From: Julie Grieves on behalf of Planning.Responses
Sent: 29 October 2012 17:52
To: Anita Gardner
Subject: FW: Ref R/193/12
Attachments: Pikett - 29-10-2012 A3 Elevations sheet 1 (E).pdf; Pikett - 29-10-2012 A3 Elevations sheet 2 (D).pdf

Sent: 29 October 2012 16:45
To: Planning.Responses
Subject: Ref R/193/12

Please find attached revised elevation drawings for your use.

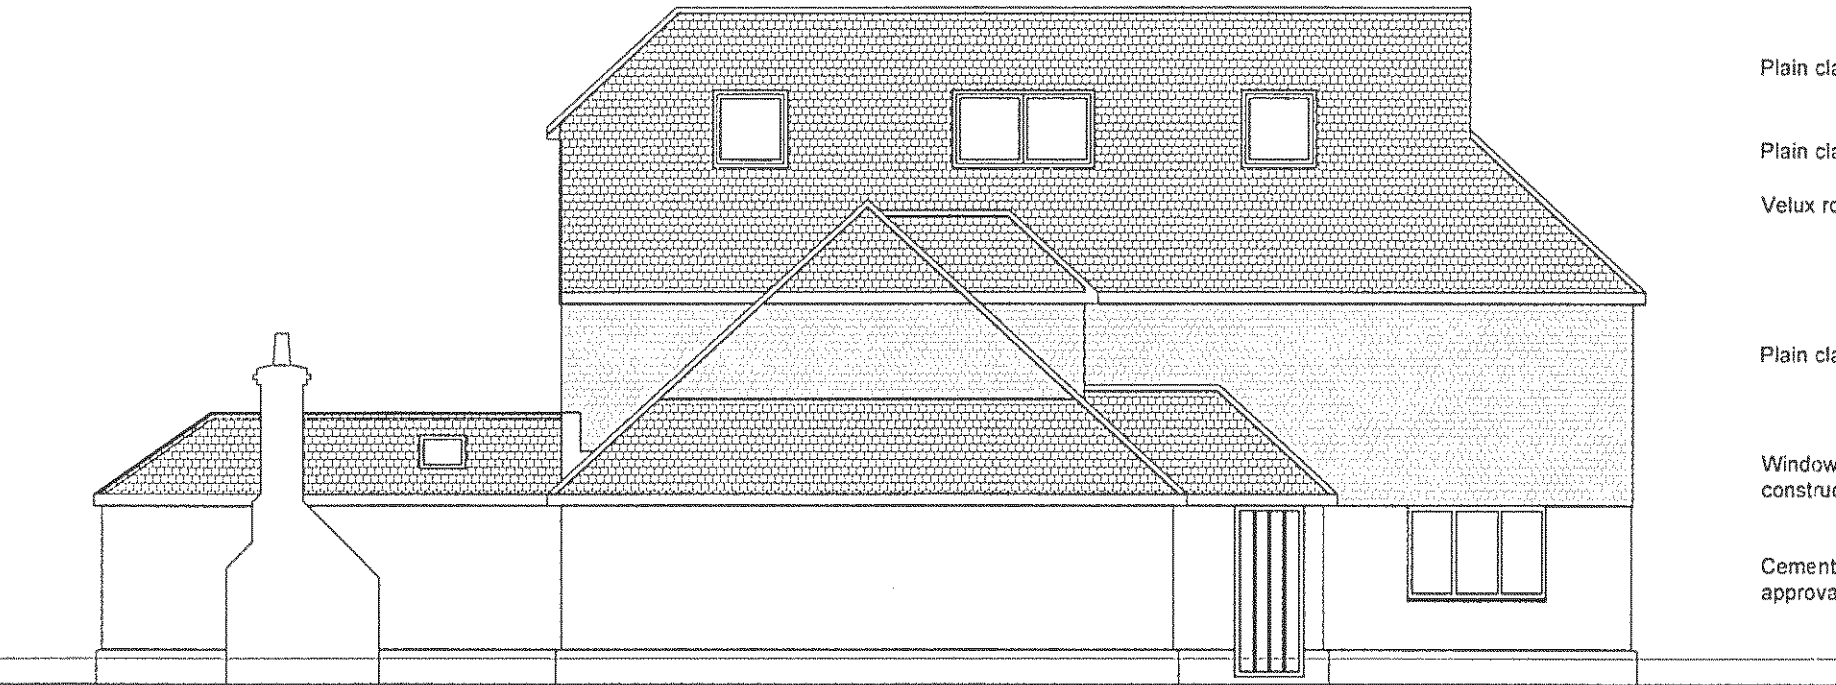
Following detailed discussions with the building control officer and fire place manufacturers it has transpired that the chimney to the rear of the property was not tall enough to draw with out the aid of a fan.

As the property is being designed and built with running cost in mind this was deemed unnecessary and we therefore have raised the chimney a little.
